Application No: BR/82/26/PL
Site Address: 63 Annandale Avenue Bognor Regis PO21 2ET
Description of works: Demolition of the existing dwellinghouse and associated buildings, and the construction of a three-storey building comprising 9 No. self-contained flats with associated landscaping, refuse storage, bicycle storage and parking spaces. This application is in CIL Zone 4 (Zero Rated) as other development.

Thank you for your internet representation made on 16th July 2026 which has been recorded as an objection with the comments as follows:

I write to formally object to planning application BR/82/26/PL. Please note that because of the limitations of characters available for upload on this portal, I lodge these points jointly and severally with my wife, Charlotte Seaton.

| DRAWING<br>Proposed<br>Block Plan         |                  |

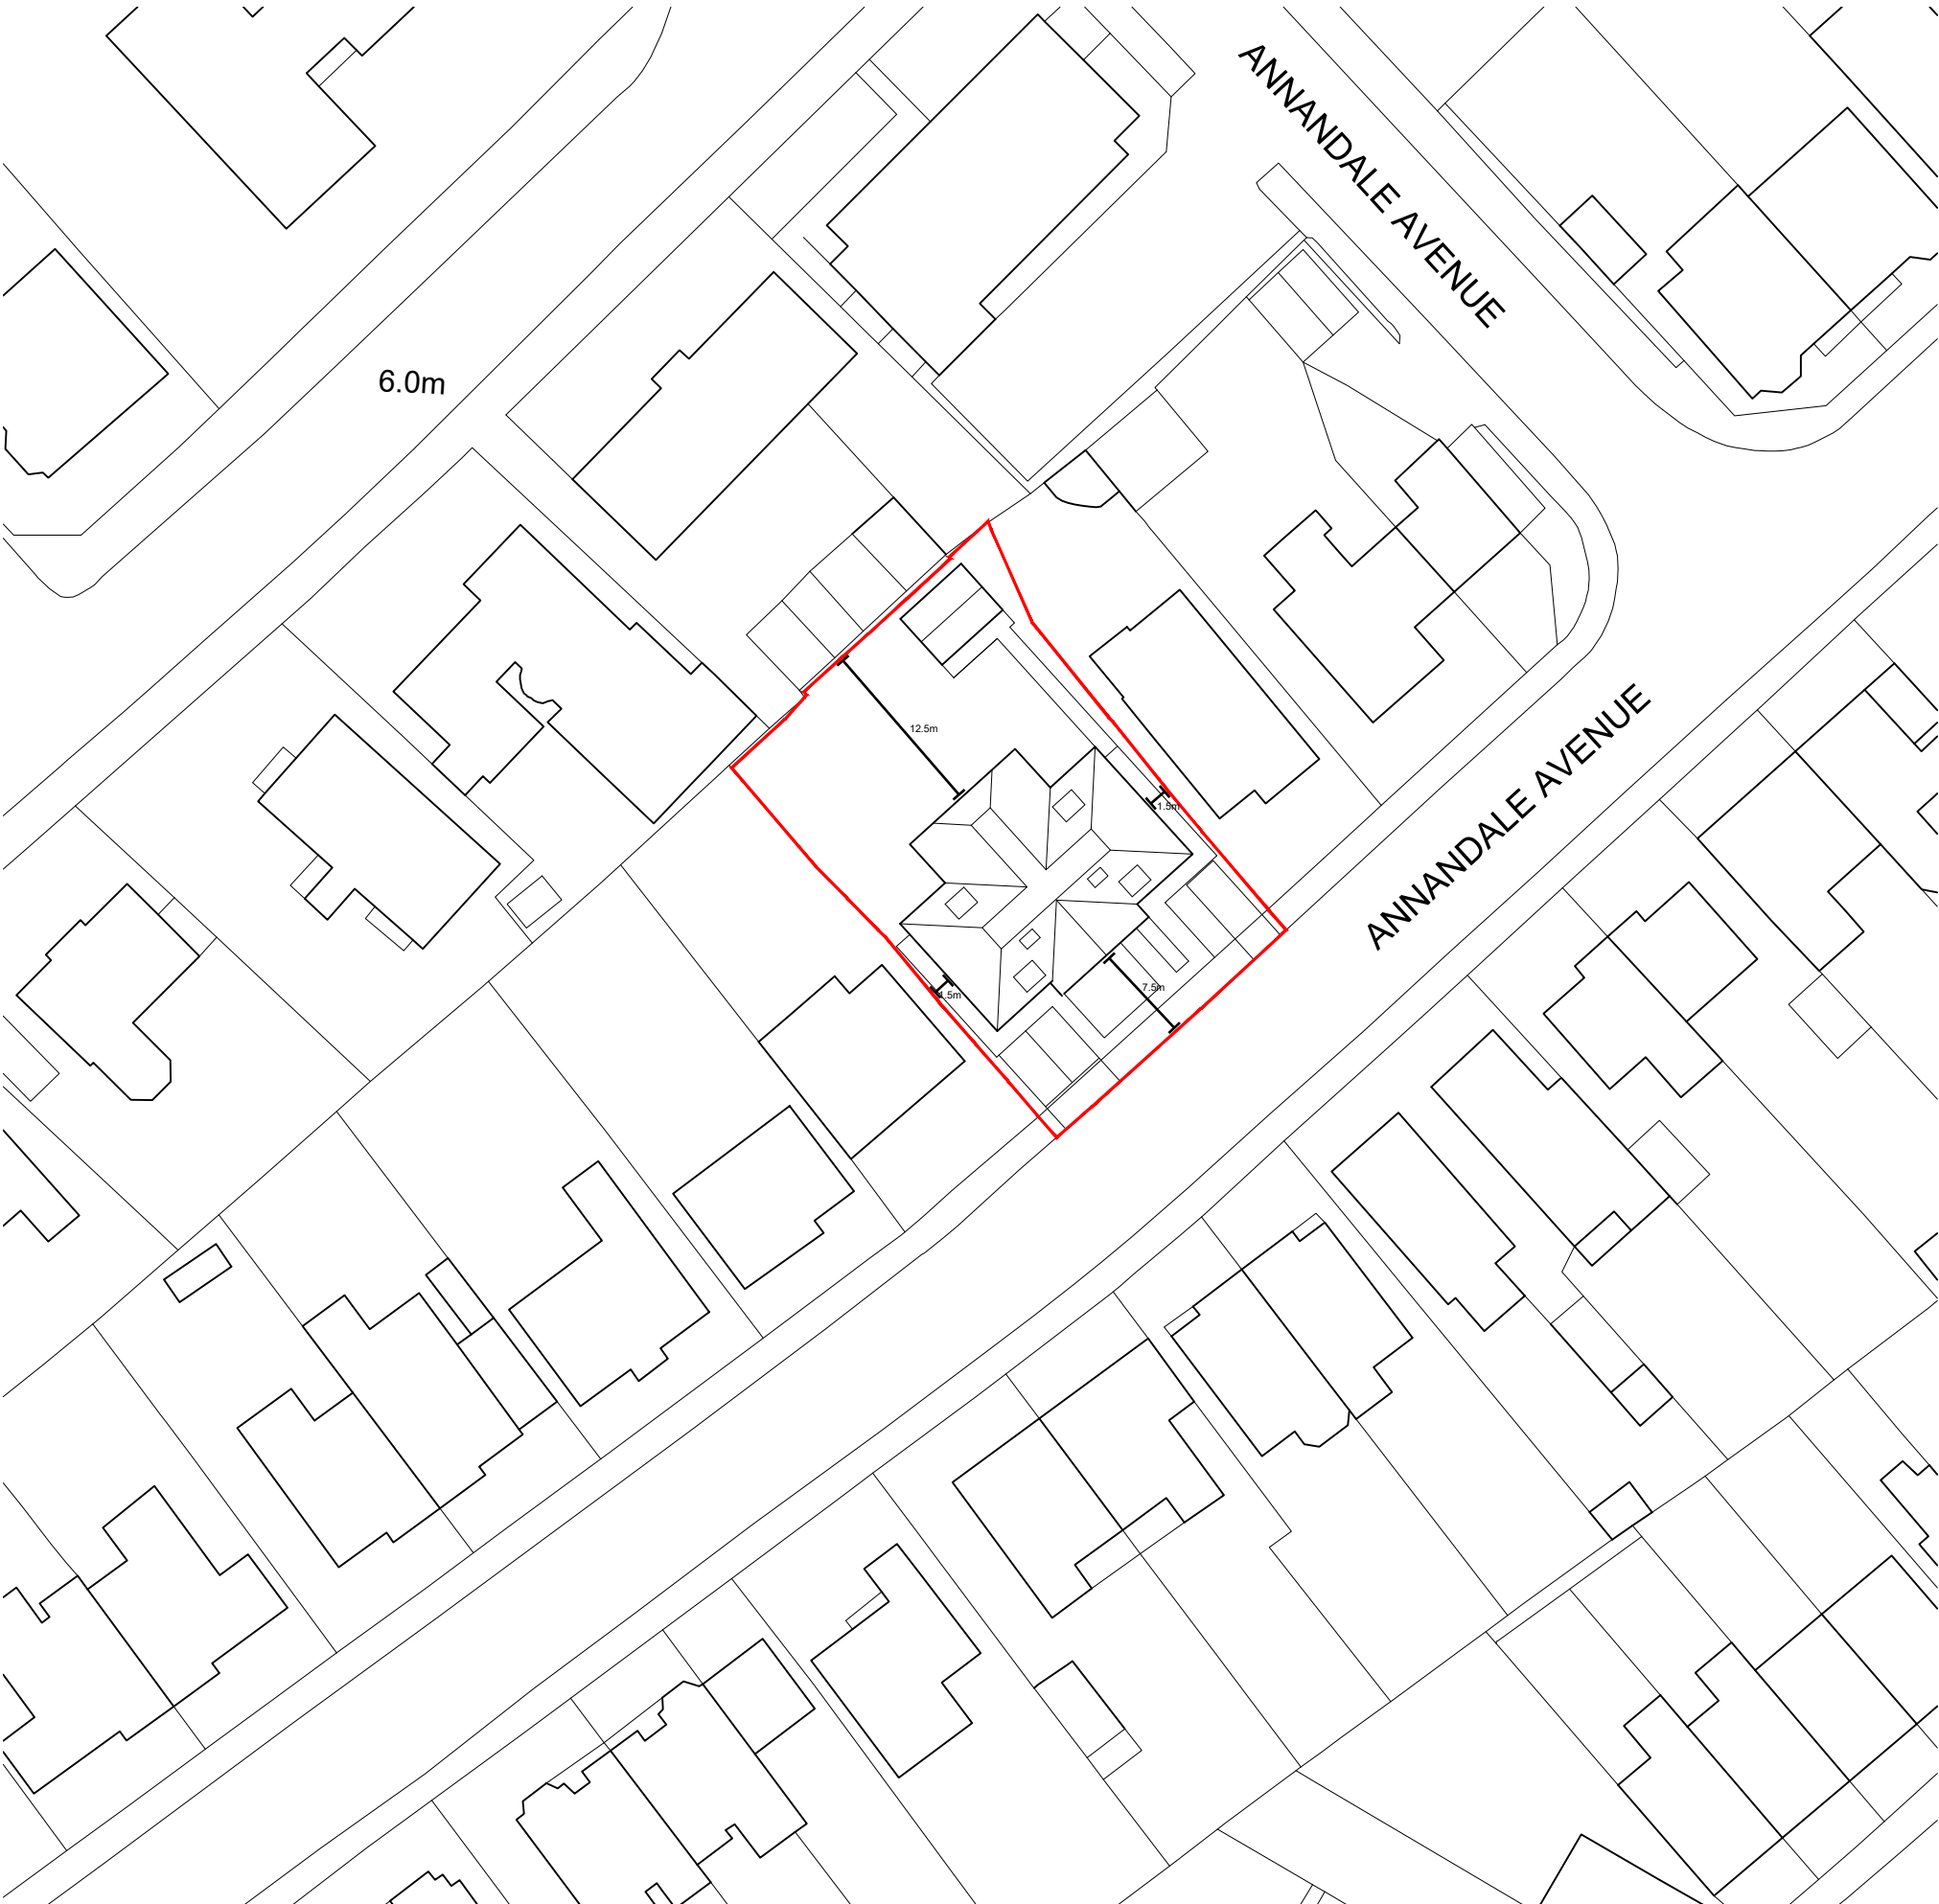
The plans indicate that only three on-site parking spaces are provided to serve nine self-contained flats. Whilst the applicant may rely upon assumptions regarding reduced private car ownership,...

DRAWING
Proposed Floor Plans

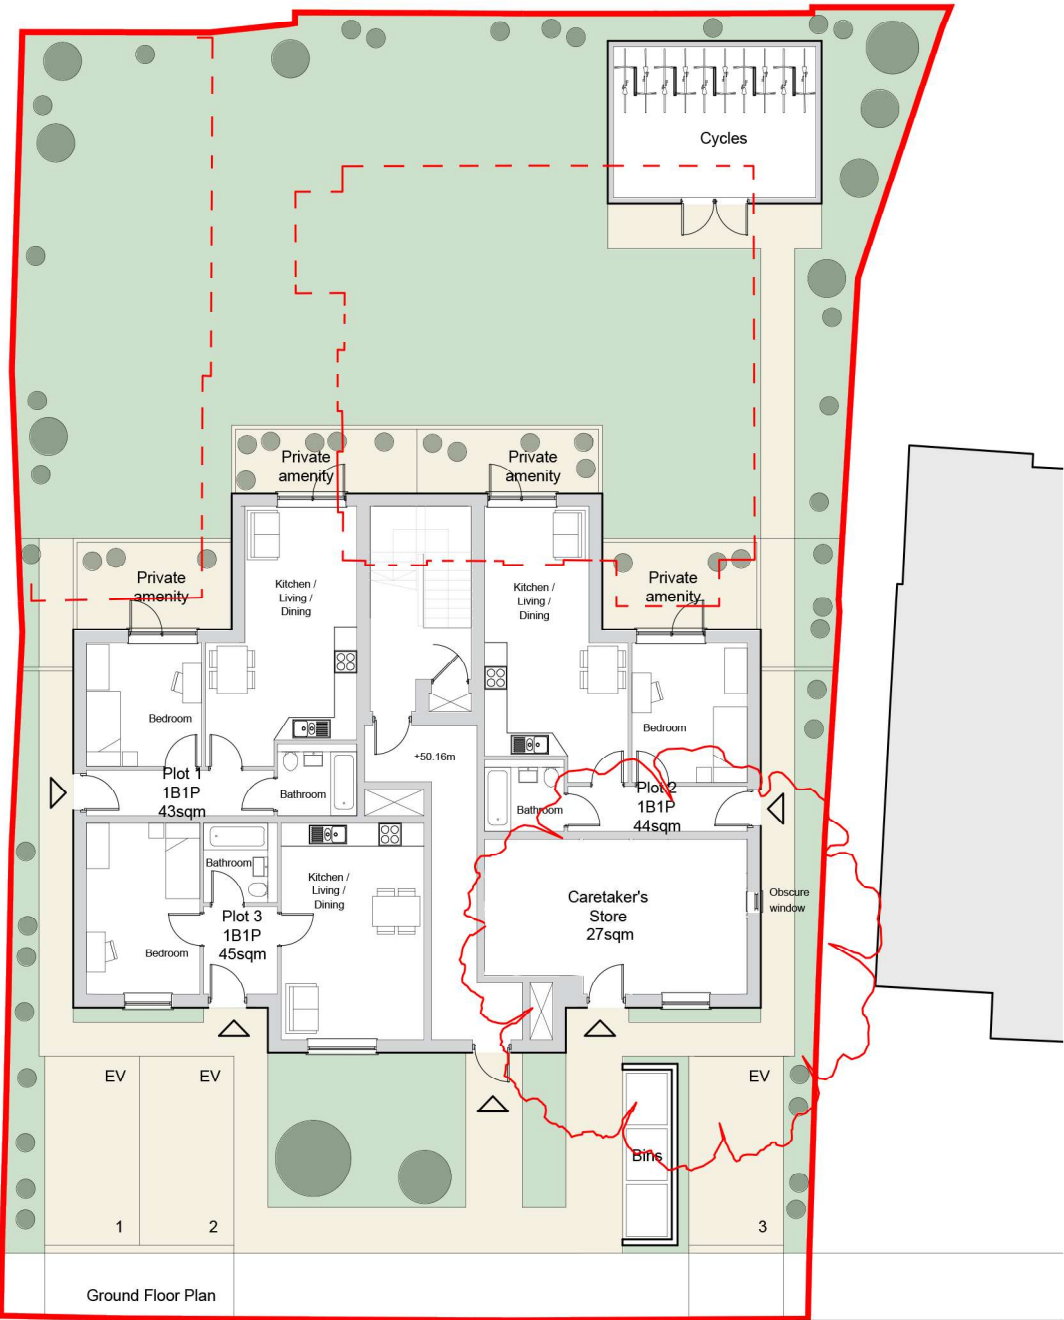
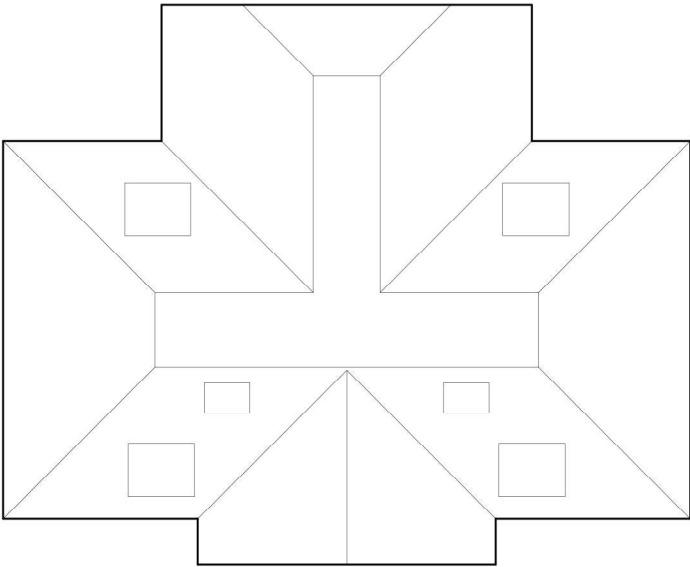
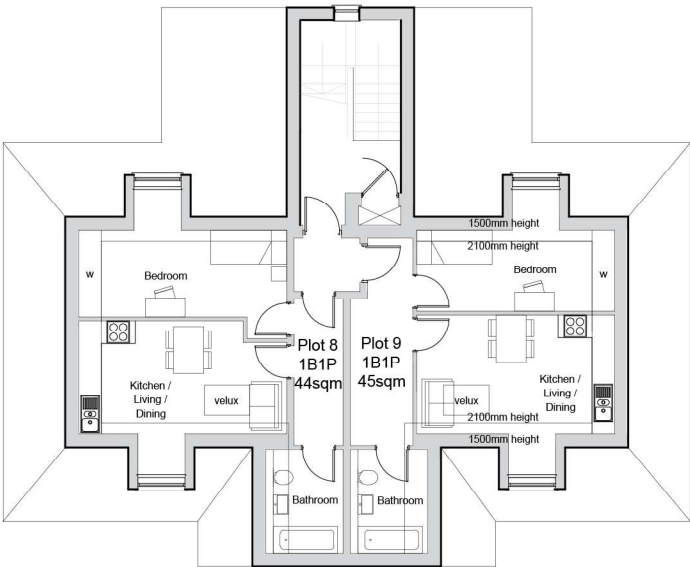
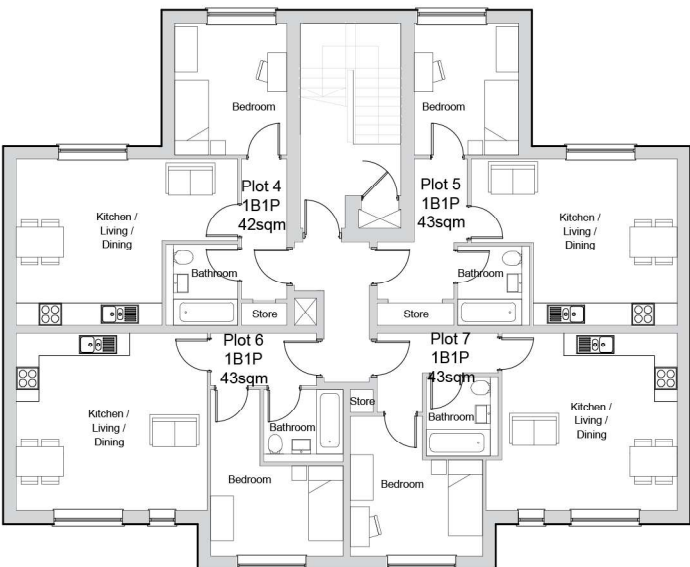
Furthermore, the introduction of multiple windows across three storeys would result in direct overlooking into neighbouring habitable rooms and private gardens, leading to a substantial loss of privacy.
